Request for Information 1, 7833 SE 28th St--revised
Project #DSR20-010 & SEP20-005

Per the comment letter dated February 16, 2021, below is the response to this comment letter along with the revised and updated plan set.

A2.1

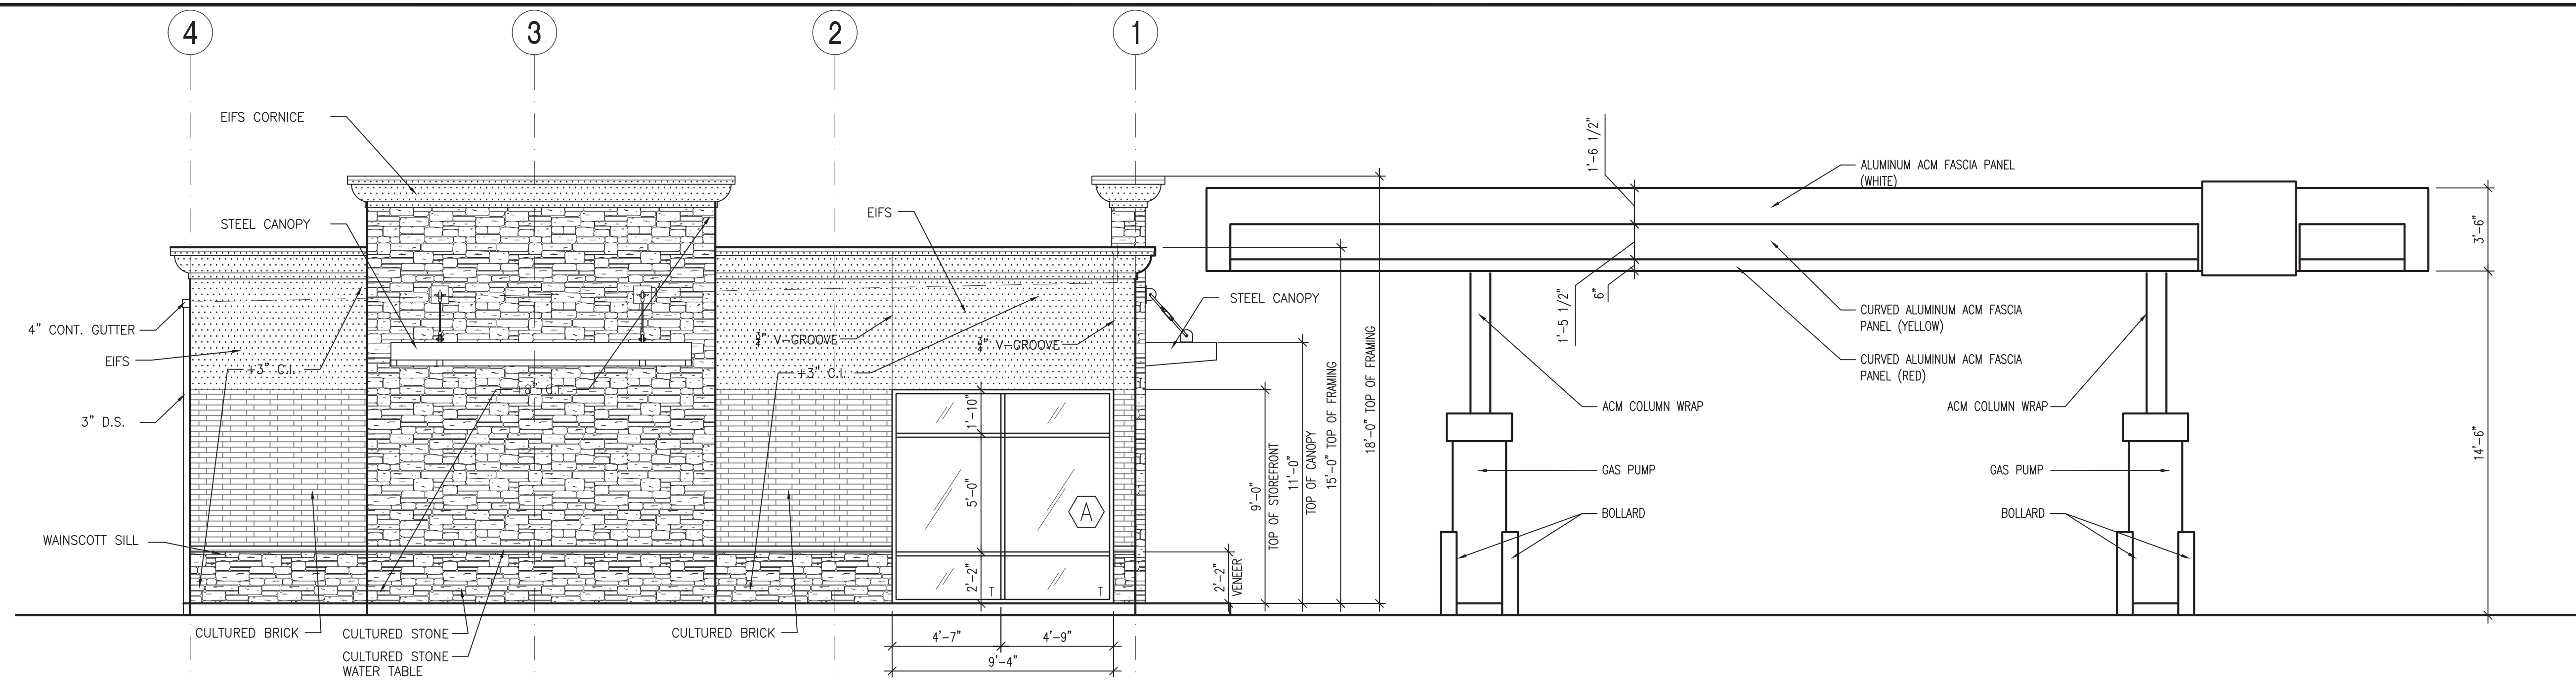
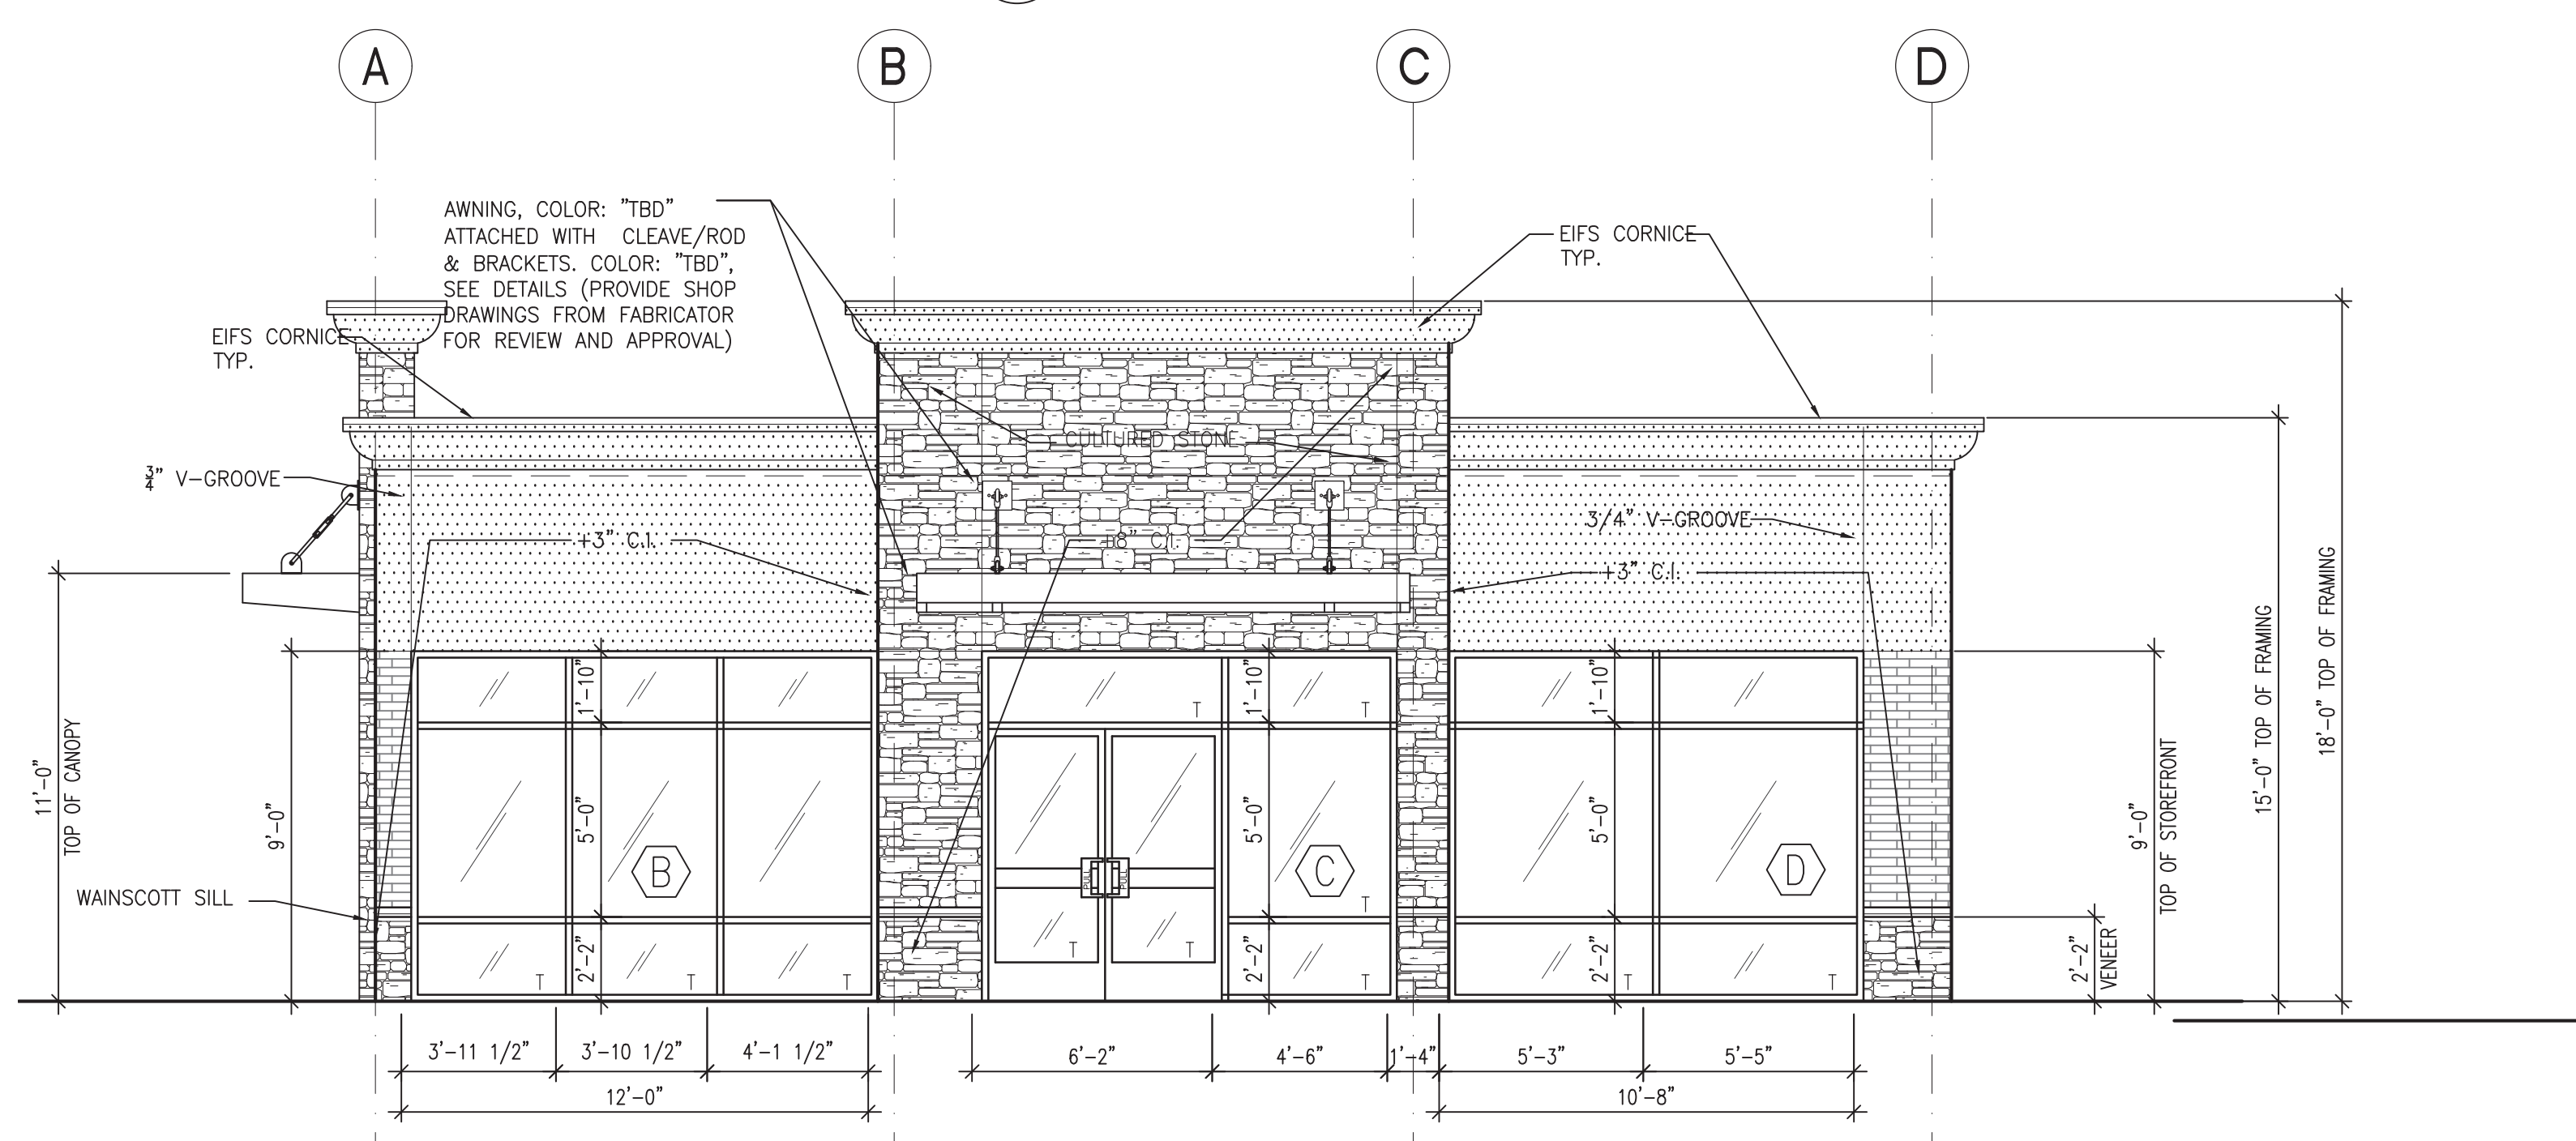
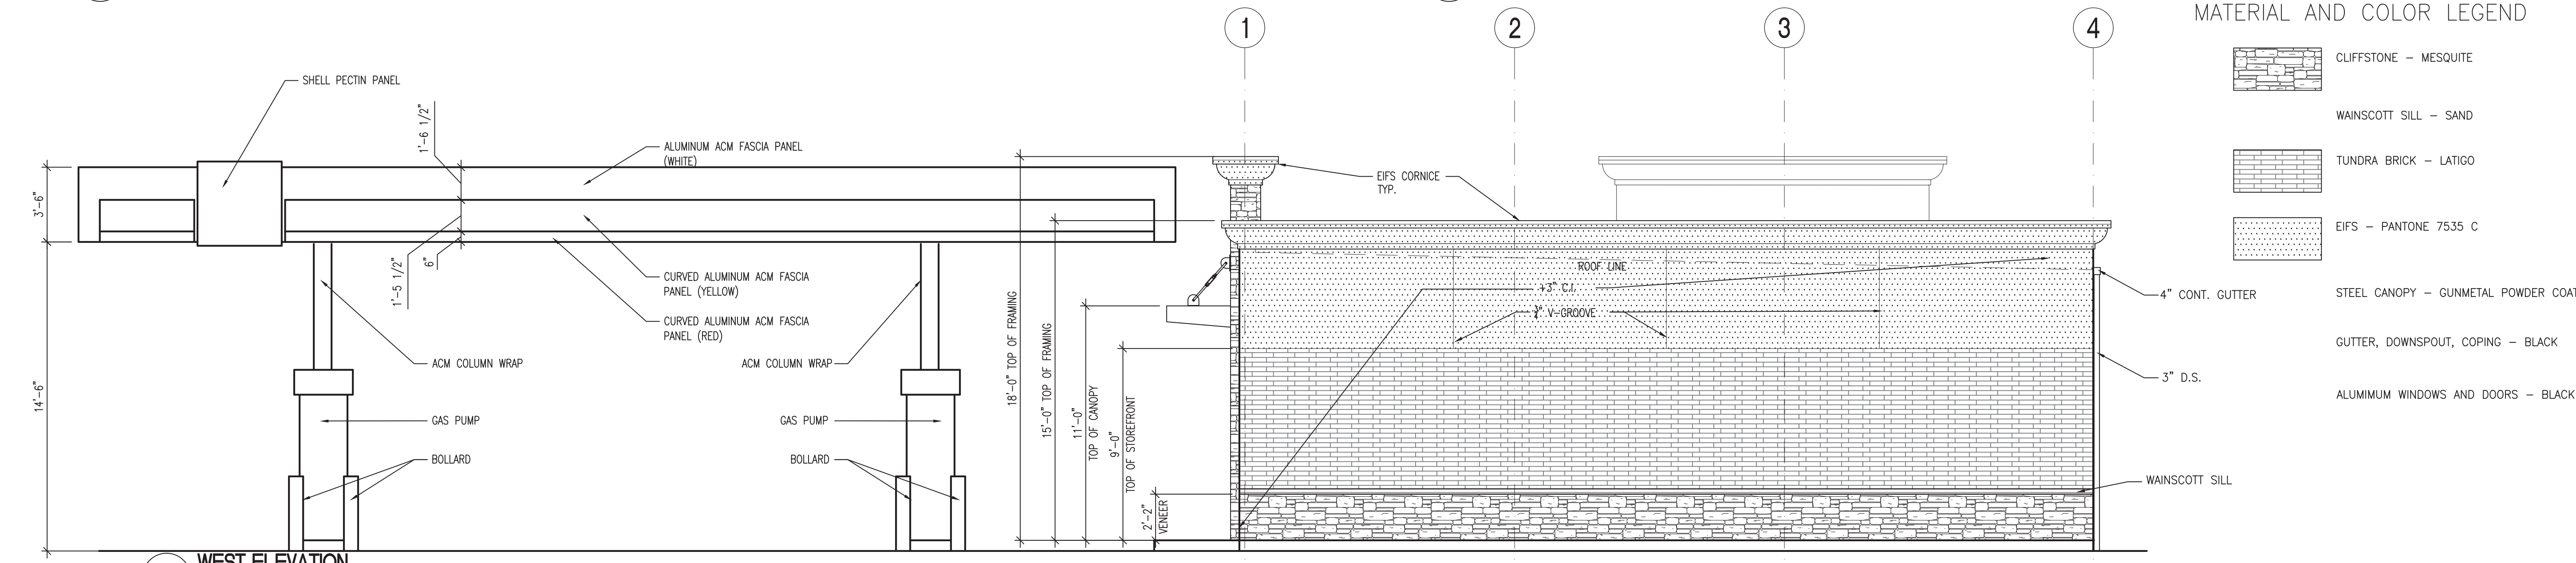
2. Sheet A2.1 shows a blank wall on the east façade that exceeds the size allowed by MICC 19.11.100(B)(5). Please revised the design to meet this standard. (Note that MICC 19.11.100 encourages transparent facades; adding transparency would be a way to fulfill both code standards.)

3. See updated east elevation with increased window area.
4. Please provide information (e.g. in the form of a project narrative) describing how EIFS is high quality and durable, meeting the standards in MICC 19.11.110(B) – Materials and Color. Note that EIFS is specifically called out as an undesired materials in MICC 19.11.110(B)(7).

SITE PLAN

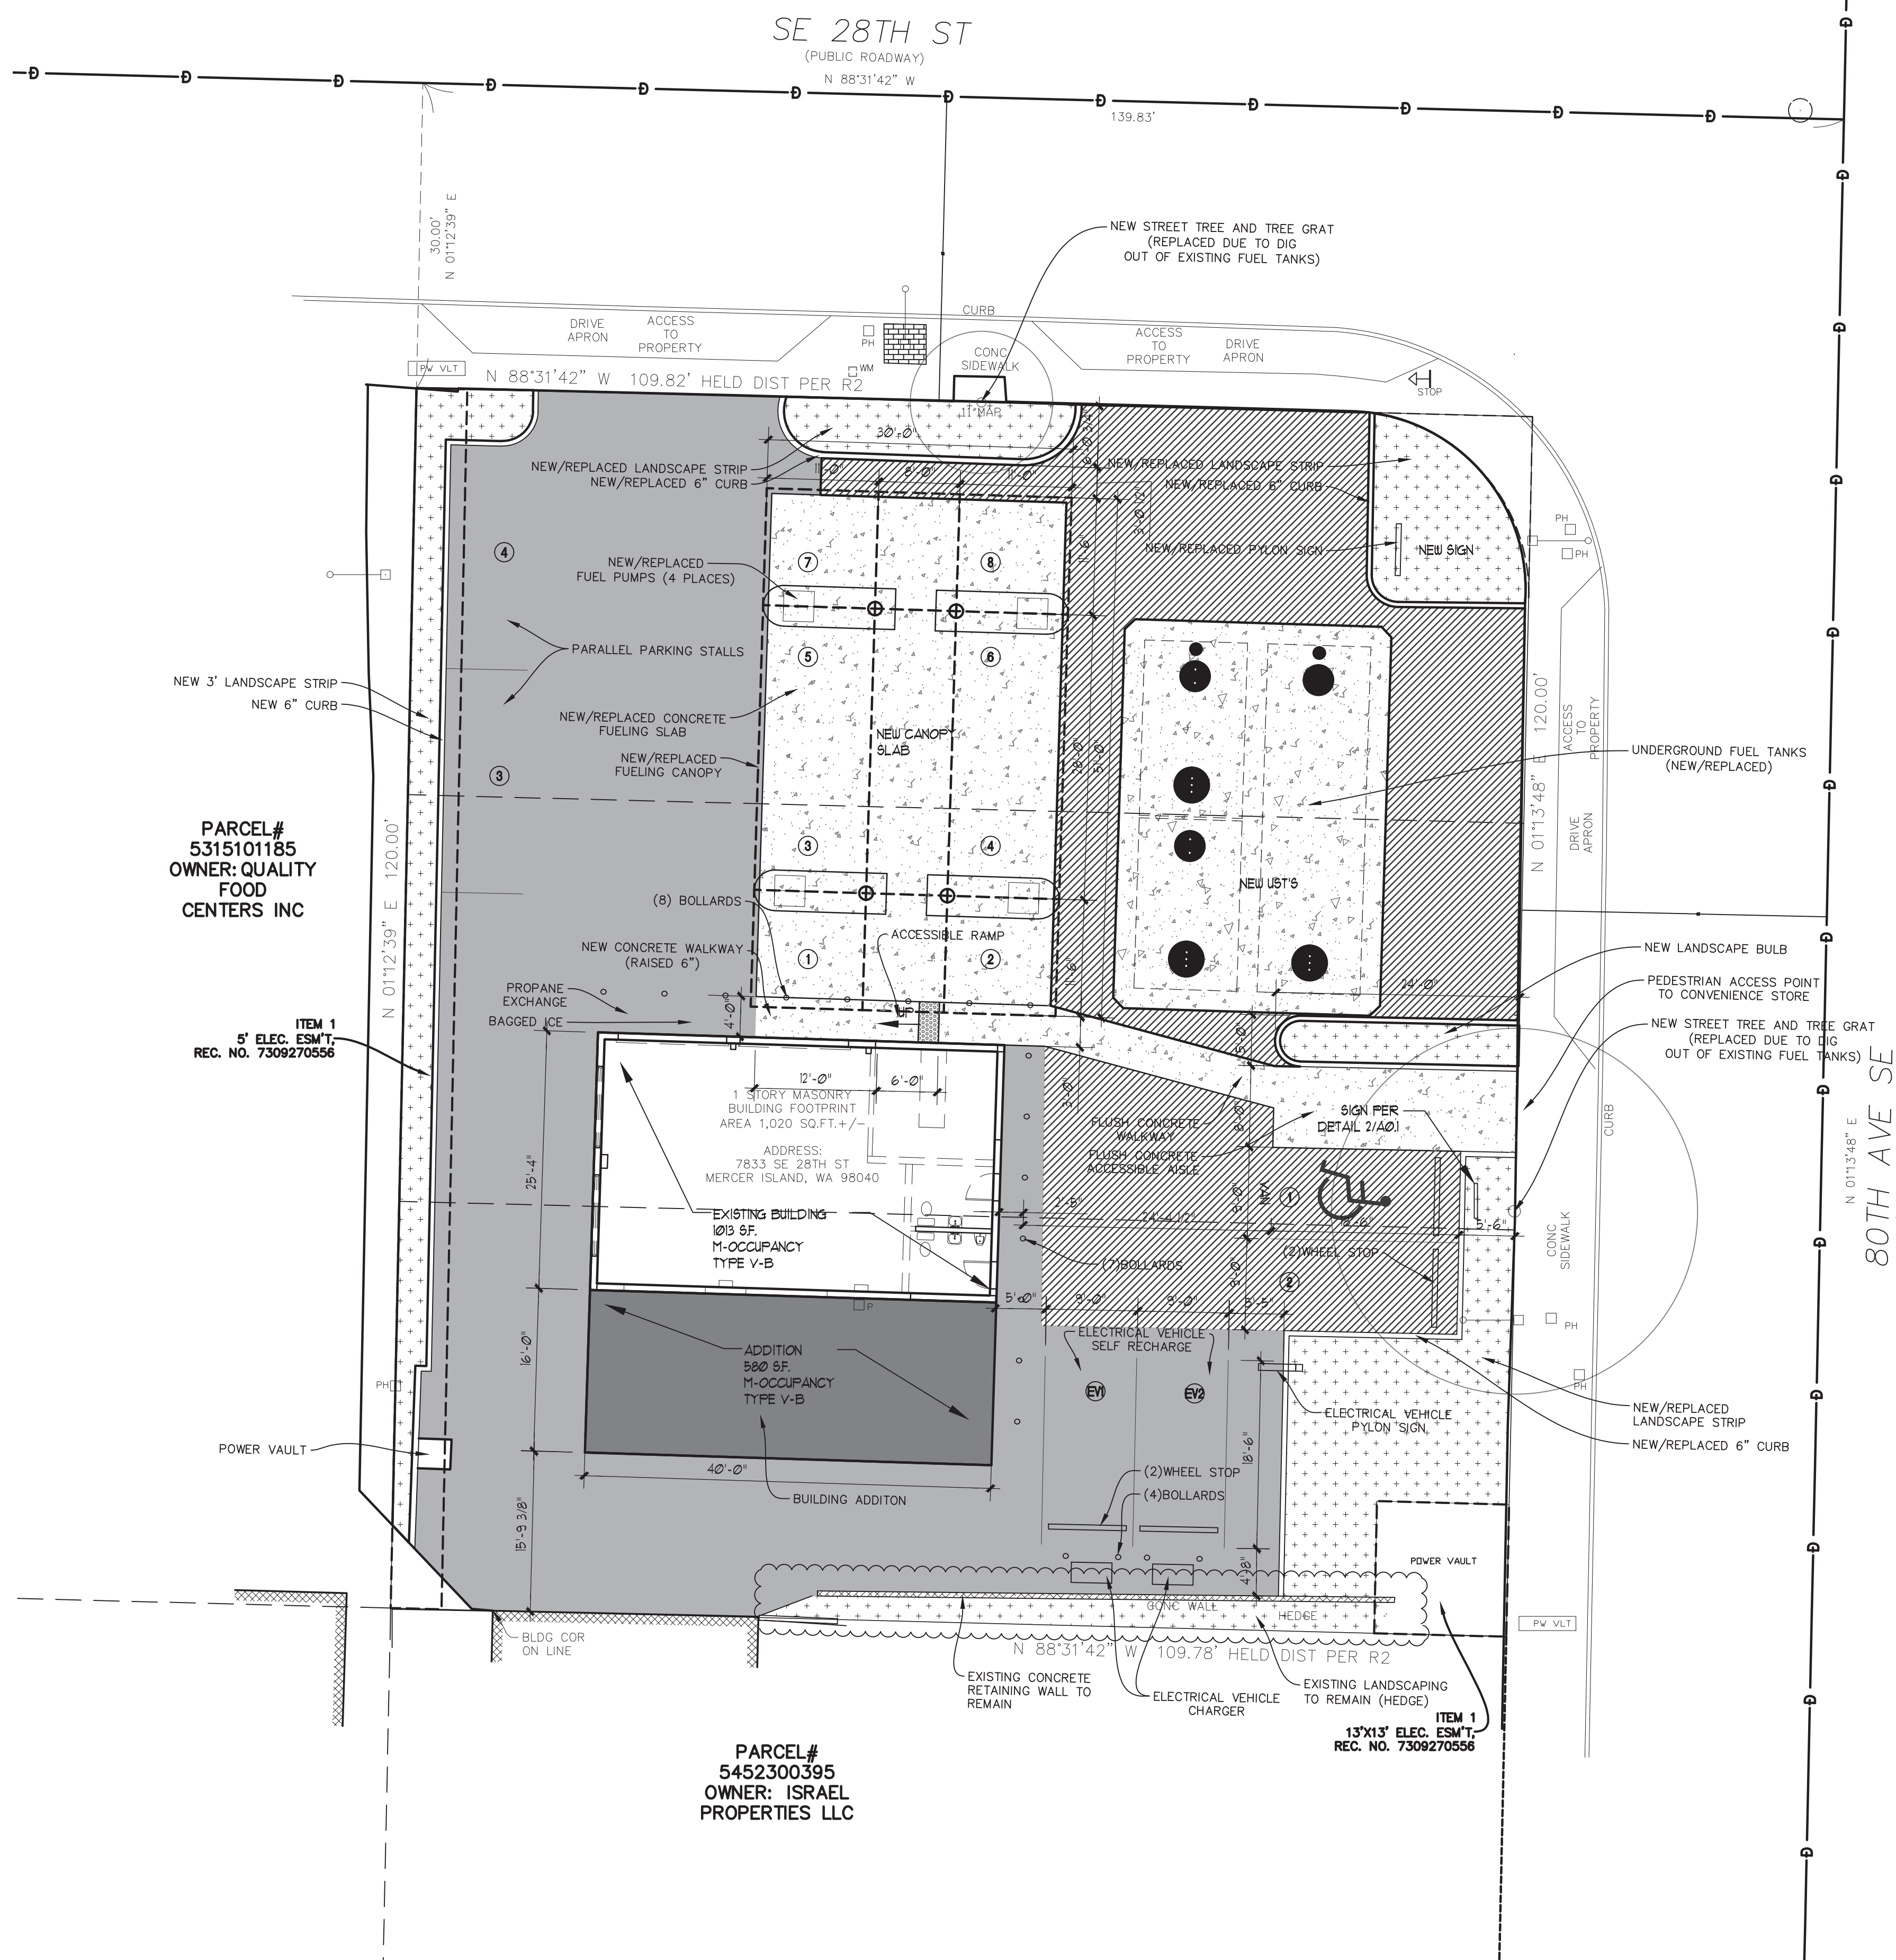
4. Please document how the parking standard in MICC 19.11.130 are met, even with the addition of new retail area.
 - a. Initially, we designed this space to meet the Mercer Island regulations for 2-3 stalls per 1,000 s.f. This puts us in a range of 3.4-5.1 stalls required. We are providing a total of 14 stalls (see site plan for descriptions and locations). We have also requested a study by Heath Engineers to verify that proper parking has been provided based on their experience. See attached letter from Heath Engineers.
